Re: **Sandia Collision**  
**1515 Yale SE**  
**Traffic Circulation Layout**  
Architect's Stamp 06-29-2021 (L15-D063)

Based upon the information provided in your submittal received 06-17-2022, the above referenced plan cannot be approved for Building Permit until the following comments are addressed:

SANDIA COLLISION 73X60X19
1515 YALE BOULEVARD, SOUTHEAST
ALBUQUERQUE, NEW MEXICO

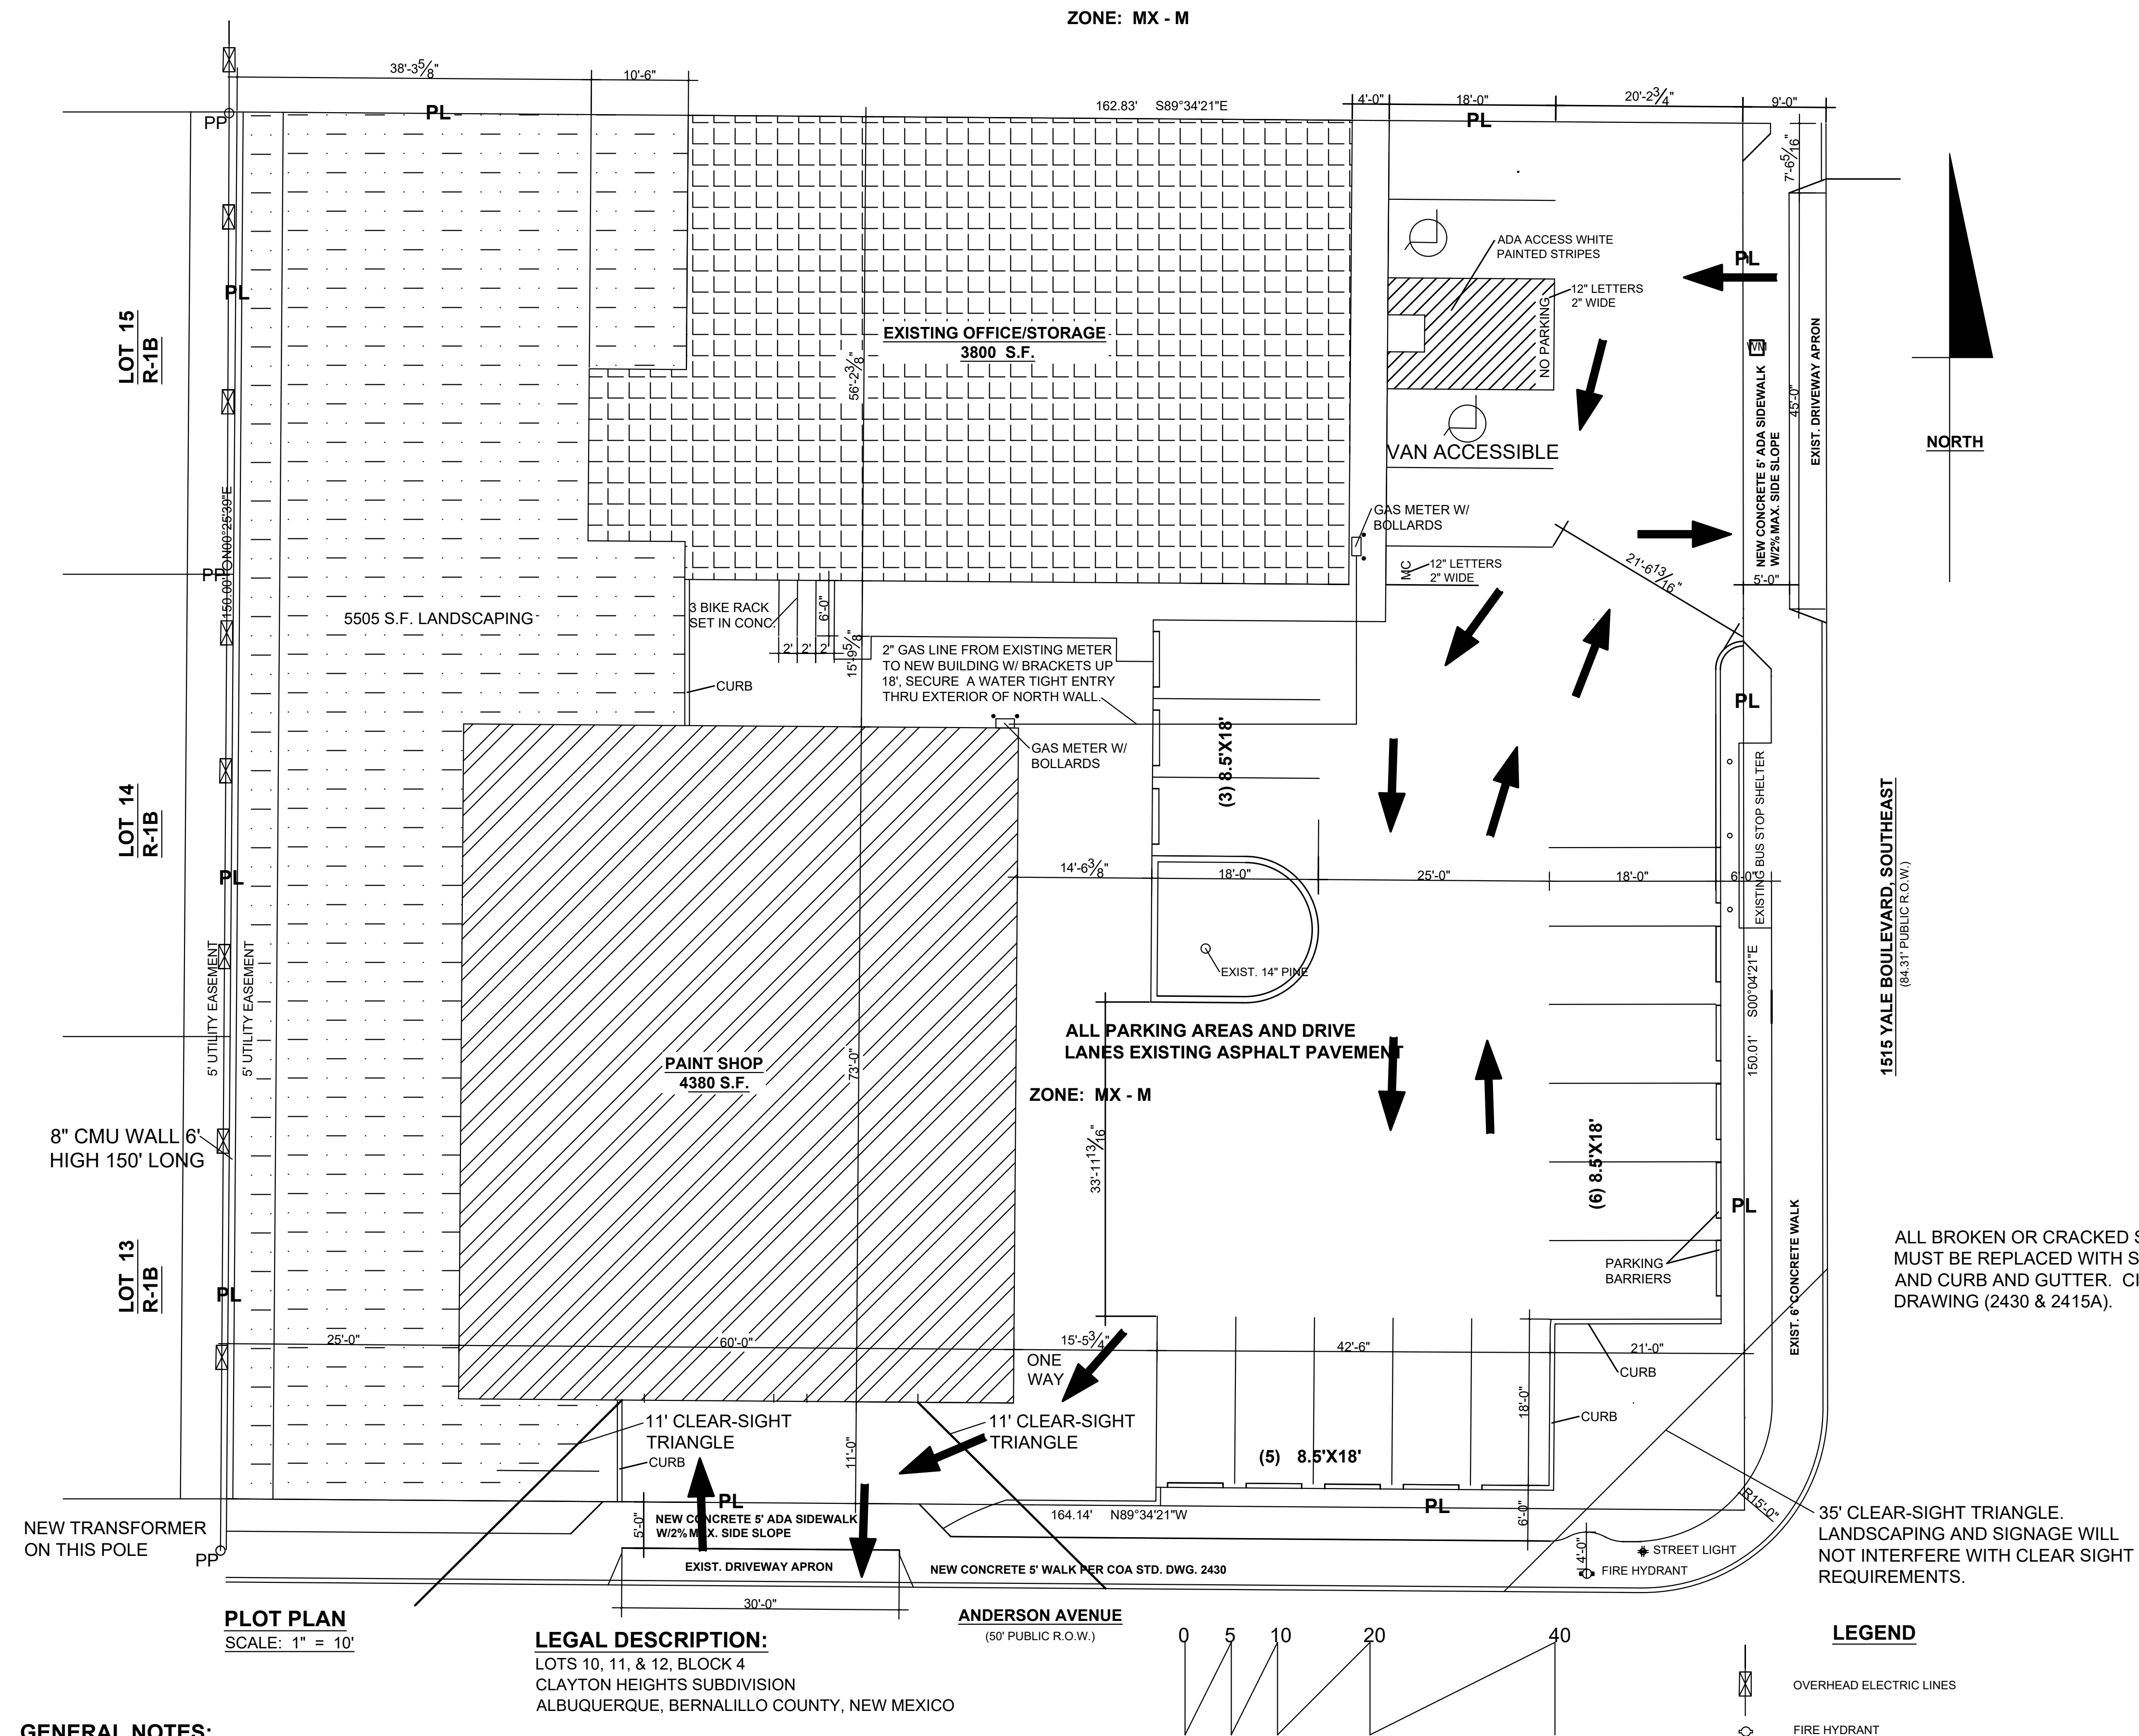
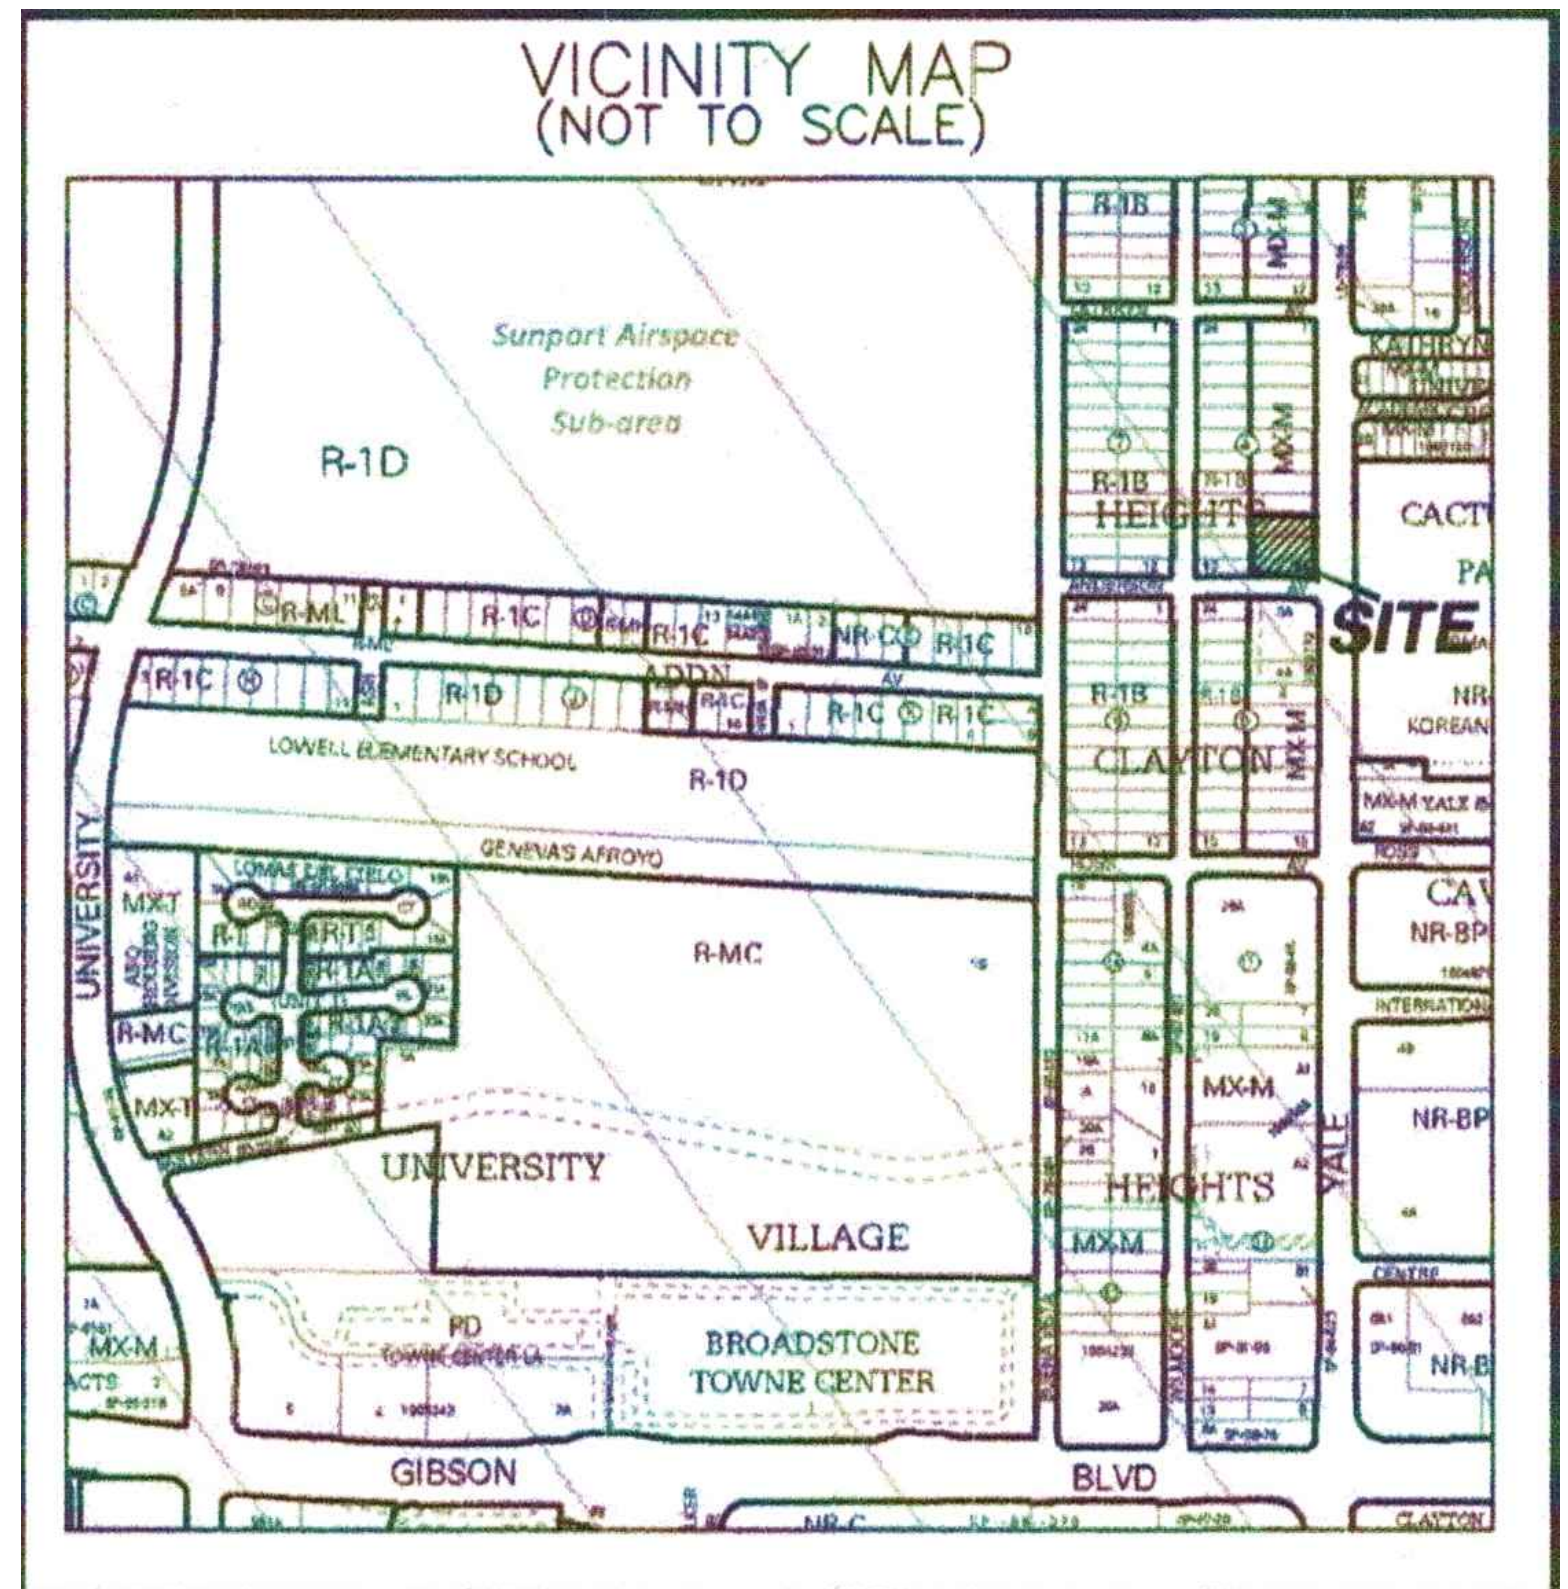
**Coordinate/discuss with Zoning.**
2. The ADA accessible parking sign must have the required language per 66-7-352.4C NMSA 1978 **"Violators Are Subject to a Fine and/or Towing."** Please call out detail and location of signs.

3. The ADA access aisles shall have the words **"NO PARKING"** in capital letters, each of which shall be at least one foot high and at least two inches wide, placed at the rear of the parking space so as to be close to where an adjacent vehicle's rear tire would be placed. (66-1-4.1.B NMSA 1978). **Provide pavement marking (NO PARKING- text) detail.**

4. **Corner Ramp Anderson/Yale:**
  - ADA curb ramps must be updated to current standards and have truncated domes installed.
  - Verify existing ramp is ADA compliant.

5. Motorcycle parking spaces shall be designated by its own conspicuously posted upright sign, either free-standing or wall mounted per the zoning code. Label pavement MC and **provide details for the proposed pavement text.**

- f. Each bicycle parking space is accessible without moving another bicycle.
7. Bicycle racks shall be sturdy and anchored to a concrete pad.
8. A 1-foot clear zone around the bicycle parking stall shall be provided.
9. Bicycle parking spaces shall be at least 6 feet long and 2 feet wide.
10. Show all drive aisle widths and radii. Some dimensions are not shown.
11. The minimum drive aisle dimensions are shown below

12. List radii for all curves shown; for passenger vehicles. Radius for delivery trucks, fire trucks, etc. is 25 ft. or larger.
13. Per DPM, a 6 ft. wide ADA accessible pedestrian pathway is required from the ADA parking stall access aisles to the building entrances. Please clearly show this pathway and provide details
14. Per the DPM, a 6 ft. wide ADA accessible pedestrian pathway is required from the public sidewalk to the building entrances. Please clearly show this pathway and provide details. ADA accessible pedestrian pathway should not be placed adjacent to a vehicular way. Please relocate to a more amicable/safe solution for this proposed 6 ft pedestrian ADA pathway to minimize pedestrian and vehicular traffic.

- Sidewalks along frontage shouldn't be tagged onto existing 3 ft sidewalk.
- Driveway is not ADA compliant and will need to be addressed.

- Driveway is not ADA compliant and will need to be addressed.
- Driveway entrance should be a curb return design instead of the existing drivepad.
- Usually driveway width for 2 way traffic should be 30 ft unless there are larger delivery trucks. Please access and determine the delivery truck size for acceptance of the larger driveway width.
- If new driveway entrance will be the solution for ADA compliant, then you will need adjacent property owner permission for the ramp pathway to be located on the adjacent property (if applicable).
- The entrance throat depth will need to be addressed per DPM requirements (DPM Table 7.4.81- Minimum Throat Length)

17. Curbing should be installed to delineate landscape, parking, and pedestrian ways and identify points of access. Please call out detail and location of barrier curb.

22. Please provide an Intersection Sight distance exhibit on Anderson Ave. projecting down north Yale.
23. Show the clear sight triangle and add the following note to the plan: "Landscaping and signage will not interfere with clear sight requirements. Therefore, signs, walls, trees, and shrubbery between 3 and 8 feet tall (as measured from the gutter pan) will not be acceptable in the clear sight triangle.
